HTE# 05-50013245 Pool  
05-50013134RR

EXISTING SEPTIC SYSTEM INSPECTION

NAME Michael Lassiter PHONE # 919 498-3201  
ADDRESS 71 Parkton Court East Sanford NC 27332  
NAME OF MOBILE HOME PARK OR S/D Highland Forest Lot 70  
NAME OF OWNER (IF DIFFERENT) Sam  
ADDRESS OF OWNER (IF DIFFERENT) \_\_\_\_\_  
PROPERTY LOCATION: STATE ROAD NAME AND # SR 91141

NEW CENTURY HOMES
 THE WALTON III
 LOT# 70 HIGHLAND FOREST
 SCALE: 1"=40'

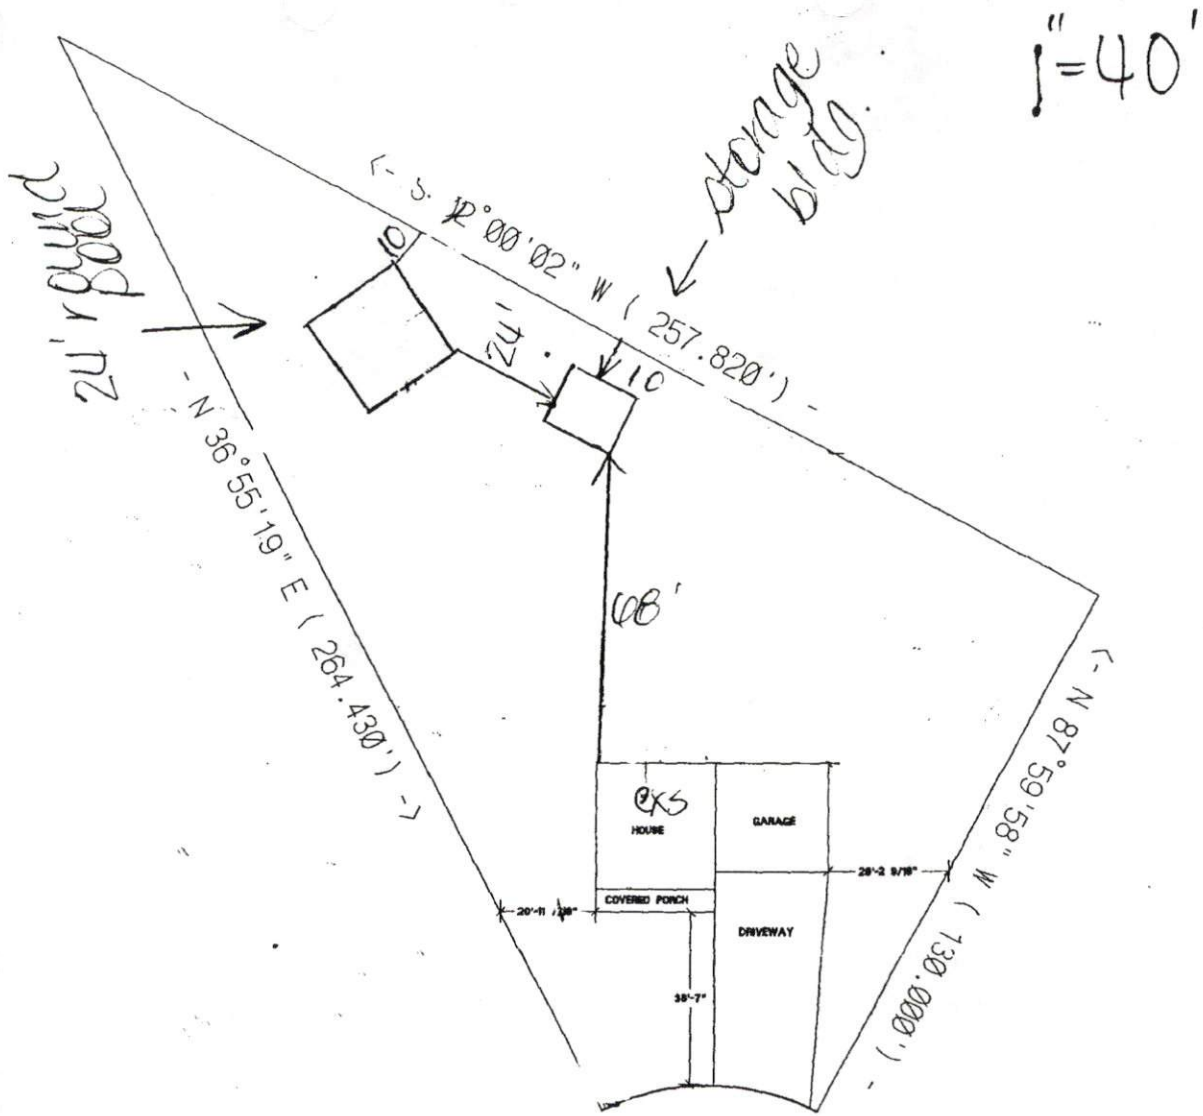
Pool is in new Area

**BUILDING MUST BE 5' FROM ANY PART OF SEPTIC SYSTEM  
DO NOT DRIVE OR PARK ON SEPTIC SYSTEM**
